Our Ref: ID 3273
Your Ref: SSD-73910208

Environmental Impact Assessment for Seniors Housing IRT Woonona Redevelopment

Elspeth O'Shannessy
Manager Emergency Risk Assessment
NSW State Emergency Service

FIGURE F50

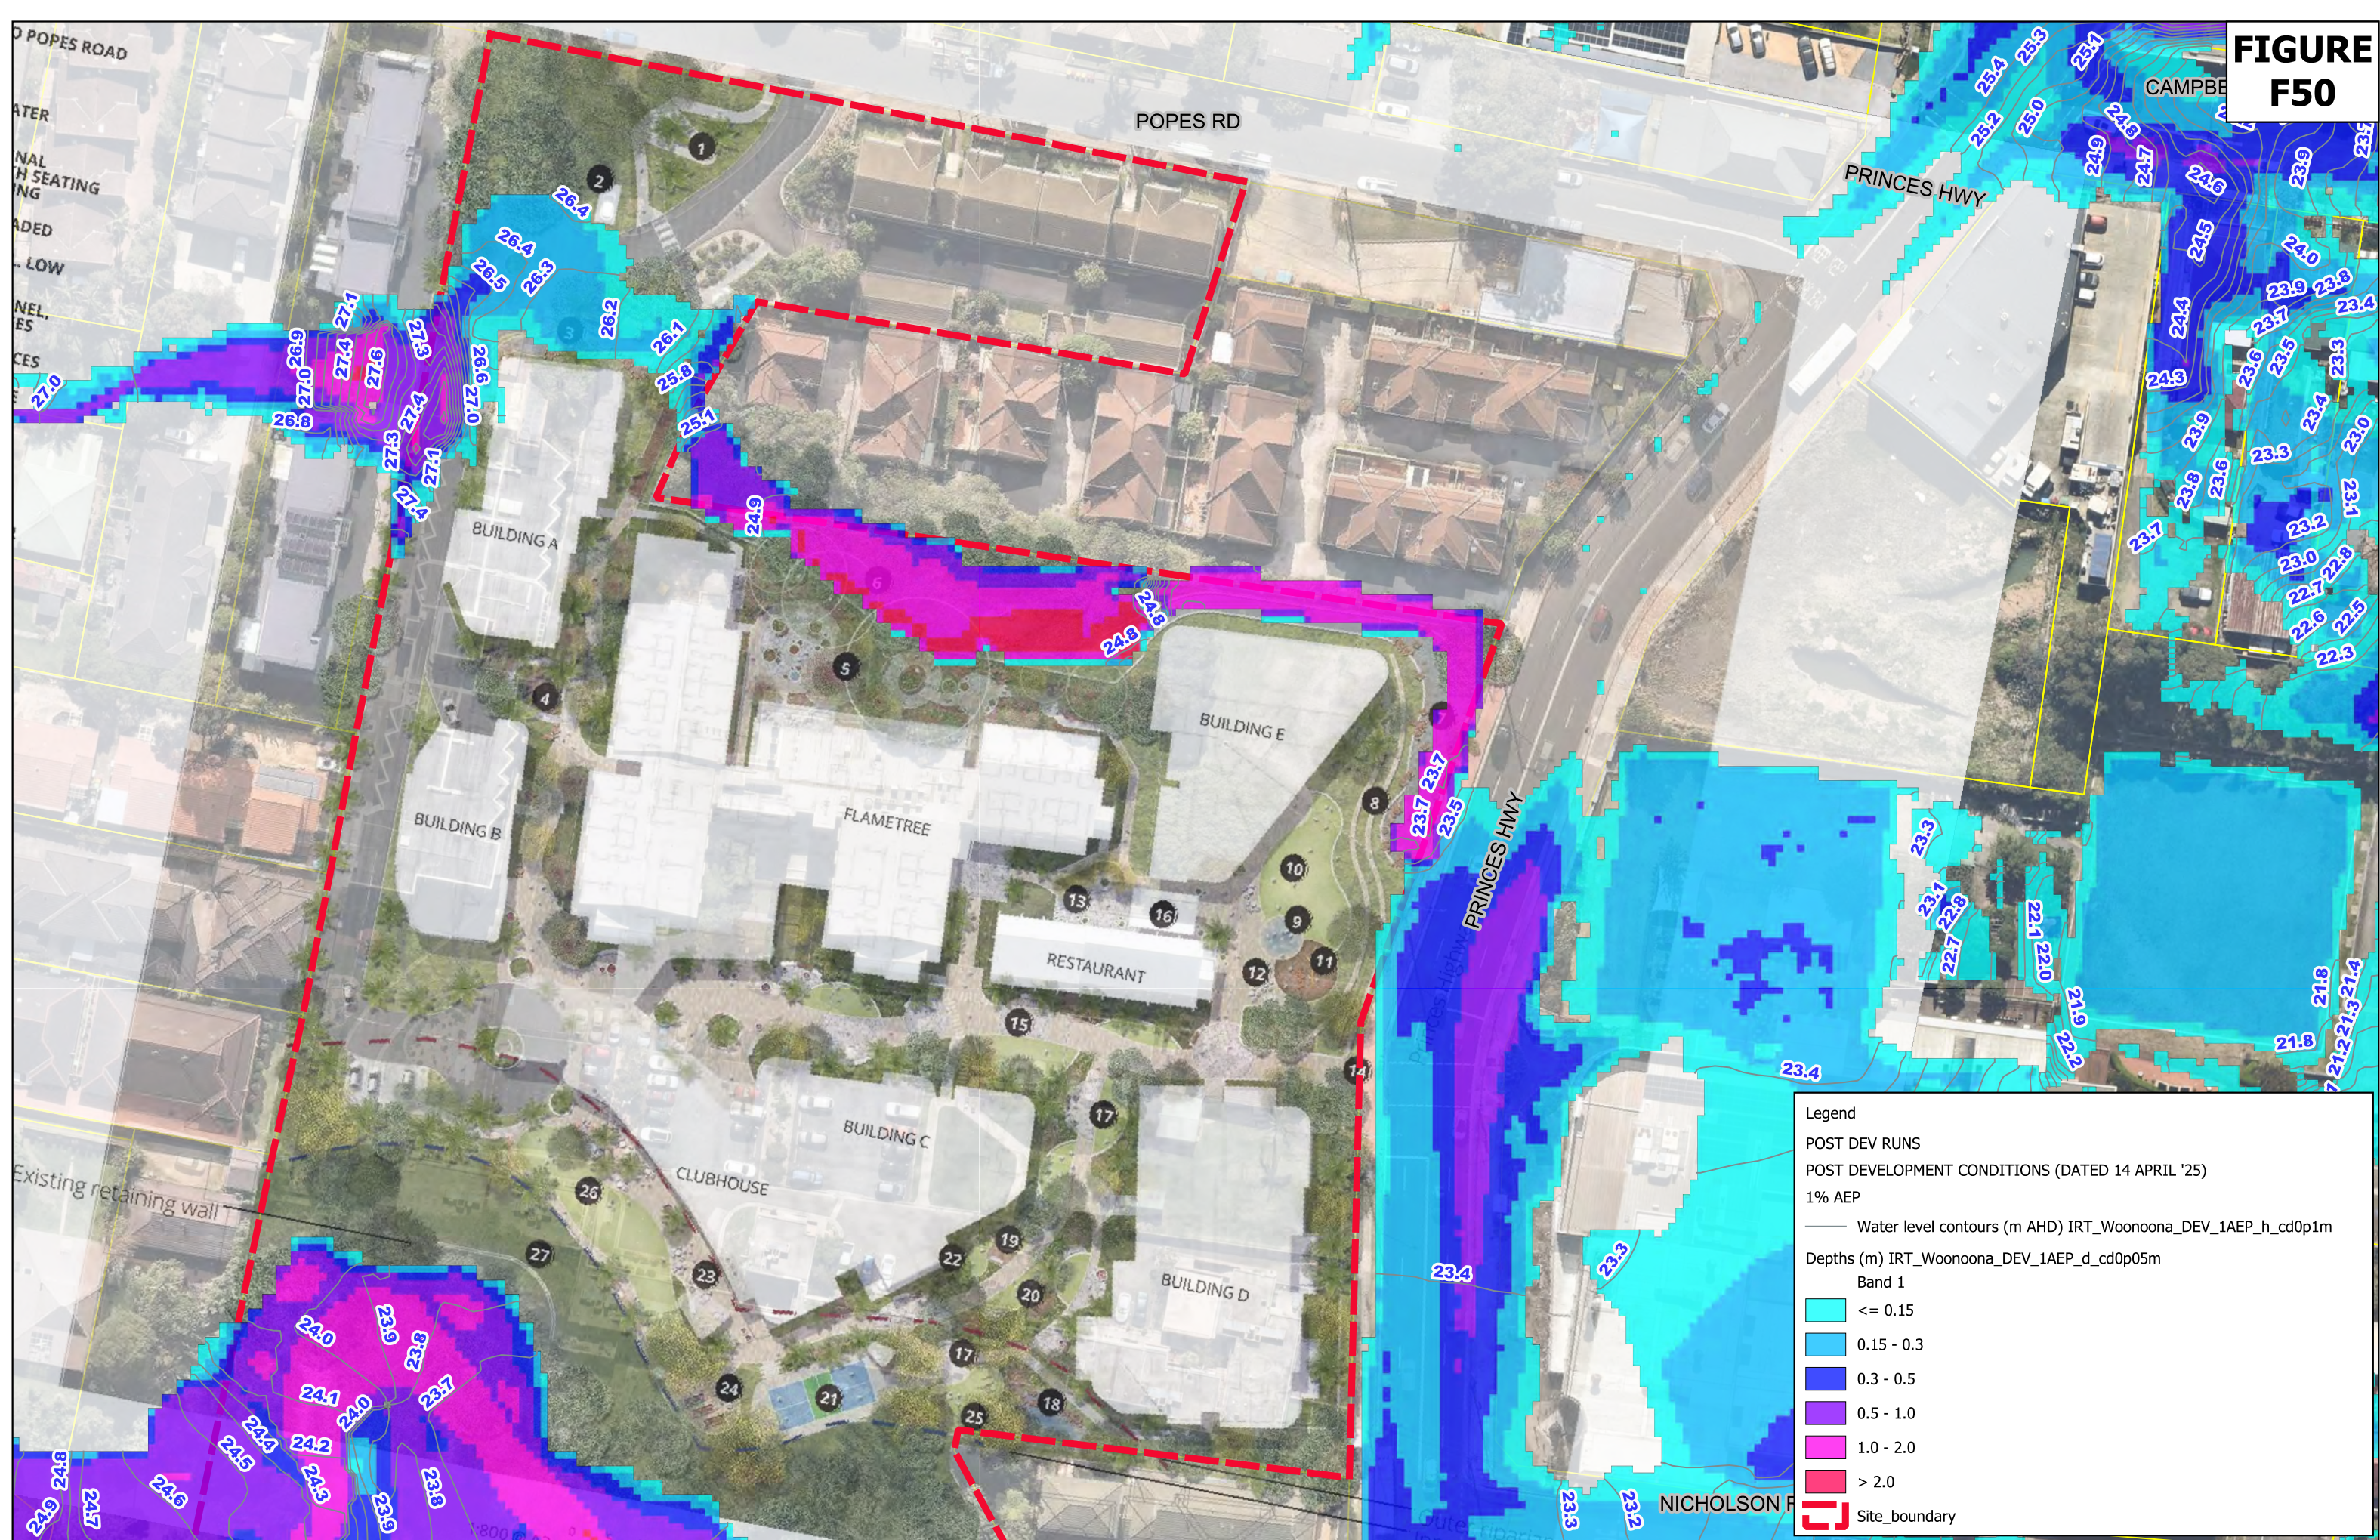
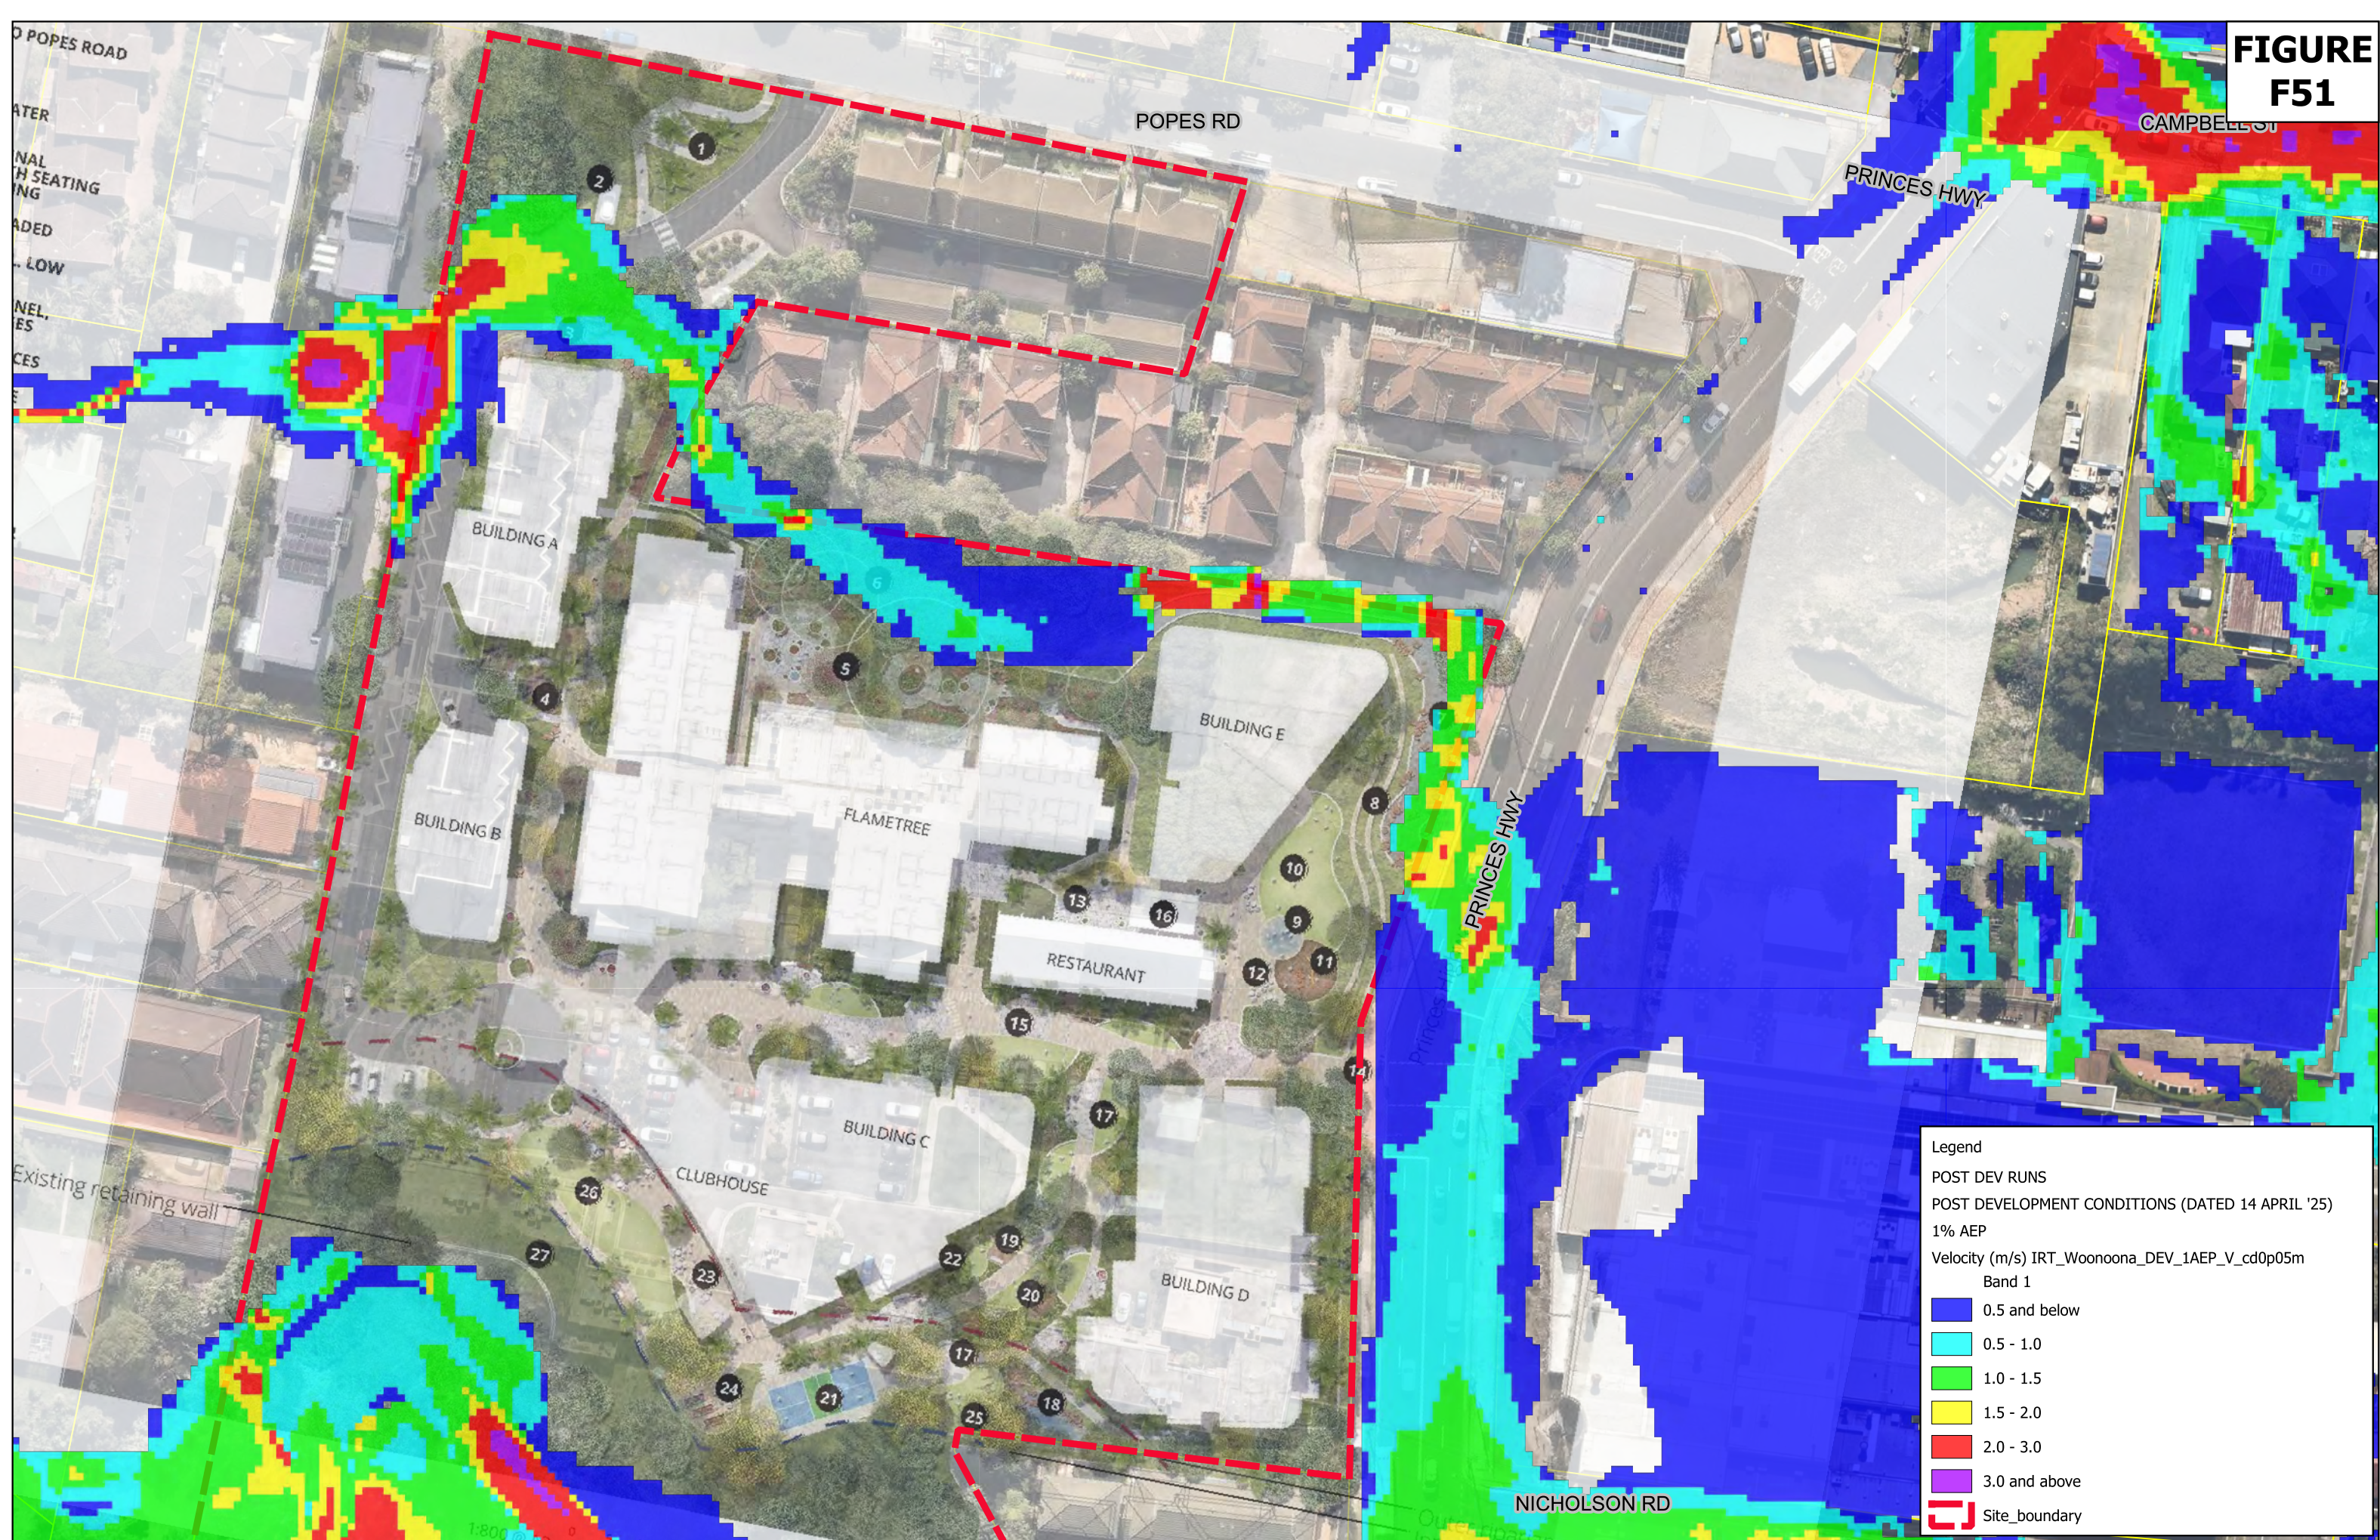
- the duration of flooding under various scenarios.
 - maps for the post developed scenario that show the flooding across the site, as currently the maps are zoomed in to exclude the highest flood risk area to the south of the site.¹

- more frequent flood events to understand the frequency of driveway flooding and potentially investigate design solutions to manage the risks
- the flood afflux up to and including the PMF
- the duration of flooding under various scenarios, including longer duration flood events
- maps for the post developed scenario that show the flooding across the site, as currently the maps are zoomed in to exclude the highest flood risk area to the south of the site.⁸
